Ref: SSD-83294209)

30 October 2025

City of Coffs Harbour Submission to SSD-83294209 - 211A – 215 Harbour Drive, Coffs Harbour - In-fill Affordable Housing development

**Figure 4: Water Quantity Catchment Plan**

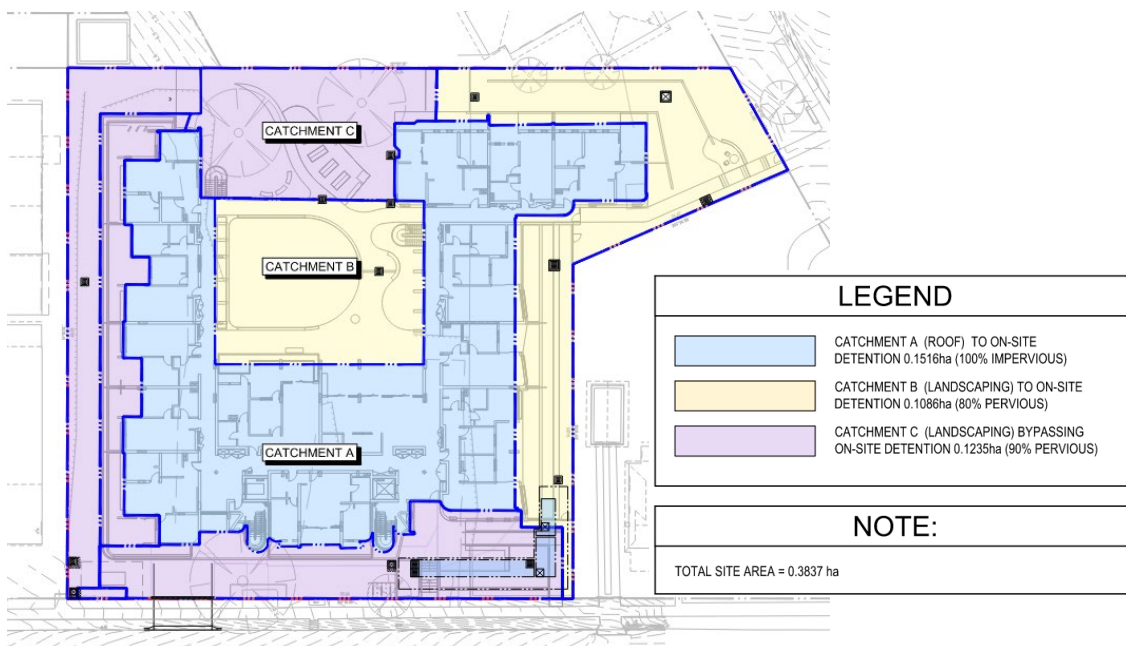
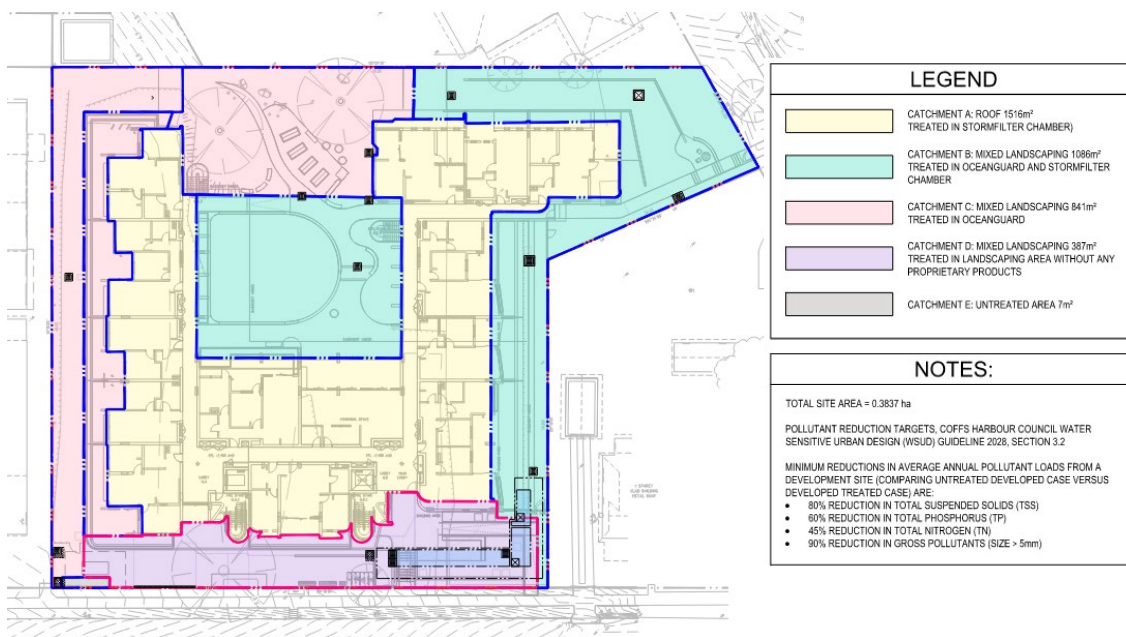
The stormwater management plan for the proposal must comply with the City's Water Management Requirements provided in Section D3.19 of the Development Control Plan and the Water Sensitive Urban Design Guidelines provided within the City's Technical Specification for Infrastructure Design.

The existing stormwater network on Harbour Drive will be required to be extended to facilitate a discharge point for the development in accordance with the City's Technical Specification for Infrastructure Design.

It is the City's recommendation that details of the stormwater management works including the required extension be provided that demonstrates compliance with Clause 7.11 of the CHLEP be provided before any determination of the application is made.

Figure 9 | Vehicle access and bus stop arrangement (source: Applicant RtS – Revised Architectural Plans)

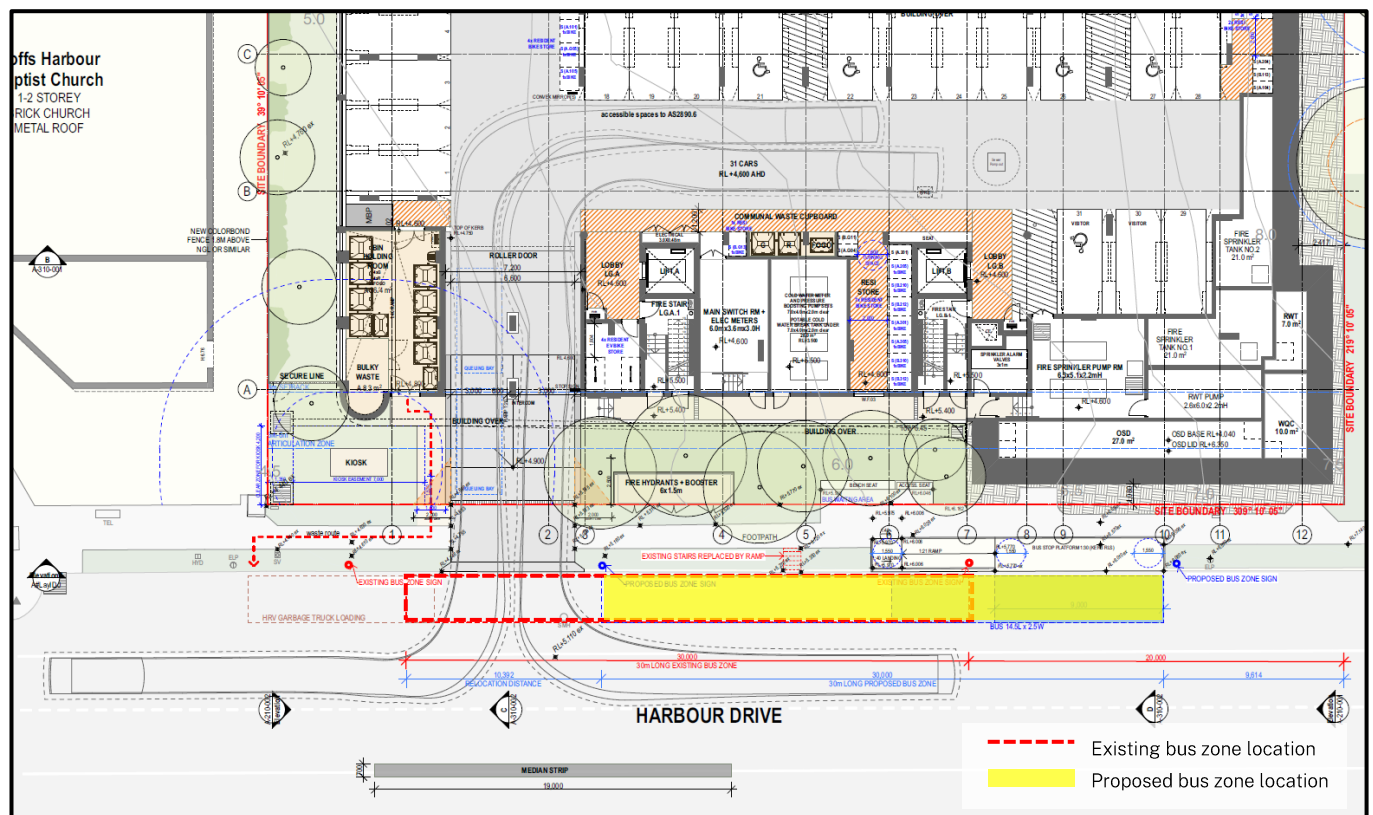
The application proposed vehicular access from Harbour Drive. The City has provided the applicant with advice previously that access from Harbour Drive is not acceptable and is not supported due to the likely impact on Harbour Drive and the surrounding local road network. It is the City's recommendation that the proposal be amended to relocate the vehicular access to North Street.

The application proposes to relocate/modify the existing bus stop located on Harbour Drive adjacent to the site. Any proposed relocation works will require approval from the City's Traffic Forum and must demonstrate compliance with the Disability Discrimination Act (DDA) and other relevant legislation or standards.
